M54 to M6 Link Road

TR010054

**8.8P(C) Statement of Common Ground
with Historic England**

March 2021

Location title: View south from the first floor of Hilton Hall
Camera model: Canon EOS 6D
Focal length: 50mm
Field of View: 65° (Horizontal)
Camera height: 1.6m
Photo taken: 02/08/2019
Coordinates: 395199, 305176
Elevation: 156m AOD

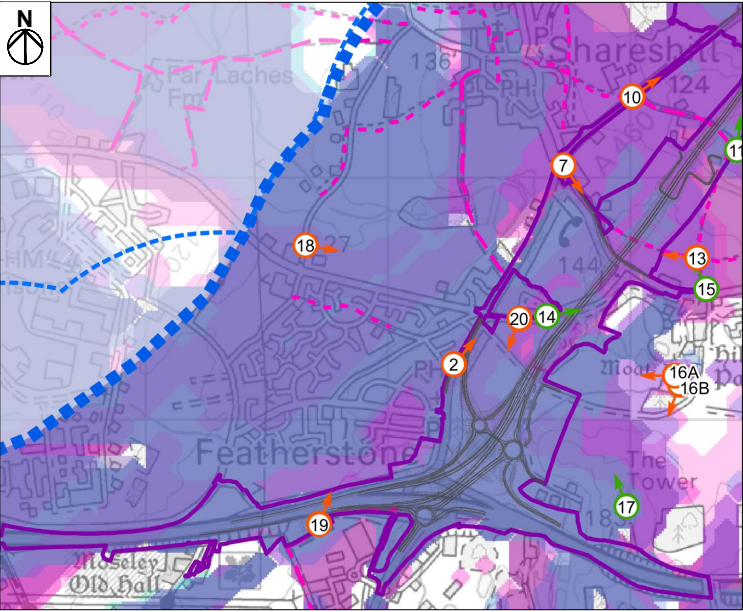
| ES Chapter | Paragraph Reference | Sub-section | Historic England Comment | Highways England Response | Status | Agreement likely? ¹ |
|------------|--------------------------|-------------|---|--|--------|--------------------------------|
| | effects' Para. 6.9.12 | | <p>vegetation. The impact would be considered by Historic England to be at least moderate rather than minor (“Partial loss or alteration to a heritage asset’s significance and/or its setting. Addition of new features that partially alter setting of a heritage asset to the extent where the significance is impacted.”)</p> <p>This assessment is based on the current condition of the planting on the west side of the Moat which is a lot more mature/overgrown than intended in the original 19th century design.</p> <p>Historic England have subsequently stated that the area of concern is that while views may not be definitely affected, there is impact caused by changes within the park detracting from the parts of the hall’s significance caused by its setting. They believe the impact to be greater than slight adverse. However, they do not believe the difference in impact levels to be very great, and it is agreed that the harm is less than substantial. Other options for the alignment here would have</p> | <p>The quotation provided by Historic England is from a superseded version of the DMRB. The current criteria within the DMRB LA104 defines a minor impact as: “Some measurable change in attributes, quality or vulnerability; minor loss of, or alteration to, one (maybe more) key characteristics, features or elements.”</p> <p>With a moderate impact defined as “Loss of resource, but not adversely affecting the integrity; partial loss of/damage to key characteristics, features or elements.”</p> <p>All assessments undertaken as part of an Environmental Impact Assessment as reported in the ES are based on the current baseline, not what it was like in the past. It is not possible or accurate to assess the magnitude of impact on what it was like in the 19th century.</p> <p>The assessment of effects on the hall has taken the impact of changes to the park into account. Only part of the park is affected. The impact on Hilton Park has taken into account impacts on individual elements of the asset such as Lower Pool and the Shrubbery as well as lesser</p> | | |

| ES Chapter | Paragraph Reference | Sub-section | Historic England Comment | Highways England Response | Status | Agreement likely? ¹ |
|--|---|--|--|---|------------|--------------------------------|
| | | | <p>resulted in a greater level of impact on Hilton Hall.</p> <p>. Historic England have reviewed the photomontages and maintain their view that that the impact of the scheme on the Grade I listed Hilton Hall would be moderate.</p> | <p>impacts on other aspects of the parkland. It is our opinion is that the assessment should remain as slight adverse.</p> <p>A summer view photomontage was provided to Historic England on 4 November 2020. A winter view photomontage was provided on 1 February. Historic England and Highways England have agreed to disagree.</p> | | |
